COUNCIL REFERENCE: 3A08/1010
CONTACT PERSON: Elizabeth Downing
YOUR REFERENCE: SSD7169

14th March, 2017

**3A Application - 3A08/1010
Lot 3 DP 568613 & Lot 30 DP 1198692 Johnsson Road, & Lot 384 DP 755952
George Evans Rd, MUNDAMIA**

I refer to your email of 21 February 2017 regarding the Biodiversity Offset Strategy dated 17 February 2017 (v1.0)

Typical bioretention trench

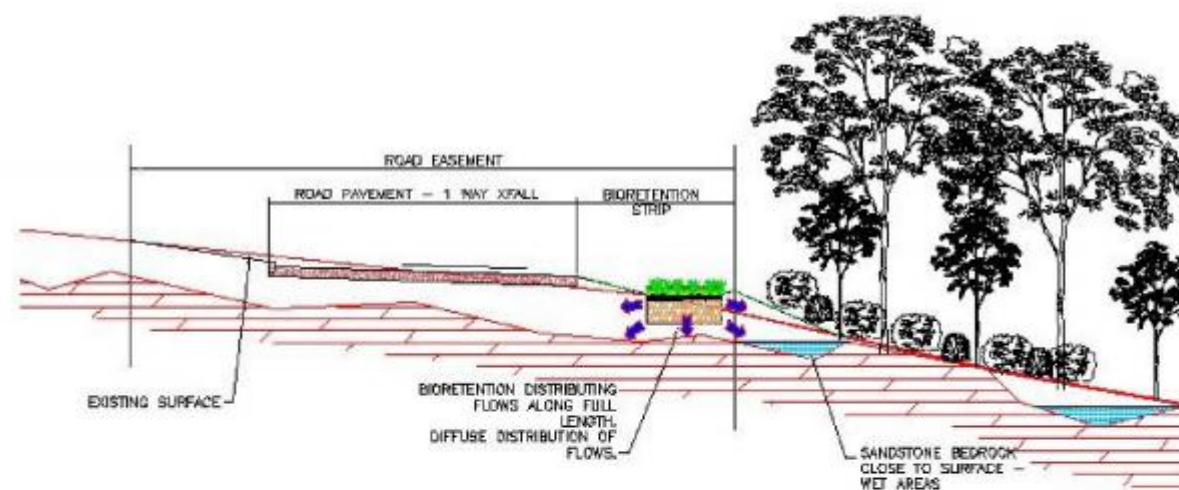
Having regard to the shallow soils over the site ranging from a maximum of around 1500mm to as shallow as 600mm, the provision of roadways with necessary pavements and underground drainage lines including subsoil drains, significantly disrupts the existing ground water. Trying to recharge the ground water throughout the development area is extremely difficult due to the need to ensure adequate drainage of road pavements and the bedding, haunching and backfill around underground drainage lines cutting off ground water flows.

The development area as designed, will essentially remove the need for any ground water recharge until the perimeter of the development due to dwelling and ancillary buildings, paving, lawns and gardens. Replenishment of the groundwater only becomes necessary at the urban bushland interface and as such this is where the infiltration regime needs to be provided. These areas come into the public domain as either public road or public reserve.

The applicant should carefully consider the overall effect of the developable area and consider where the groundwater needs to be recharged.
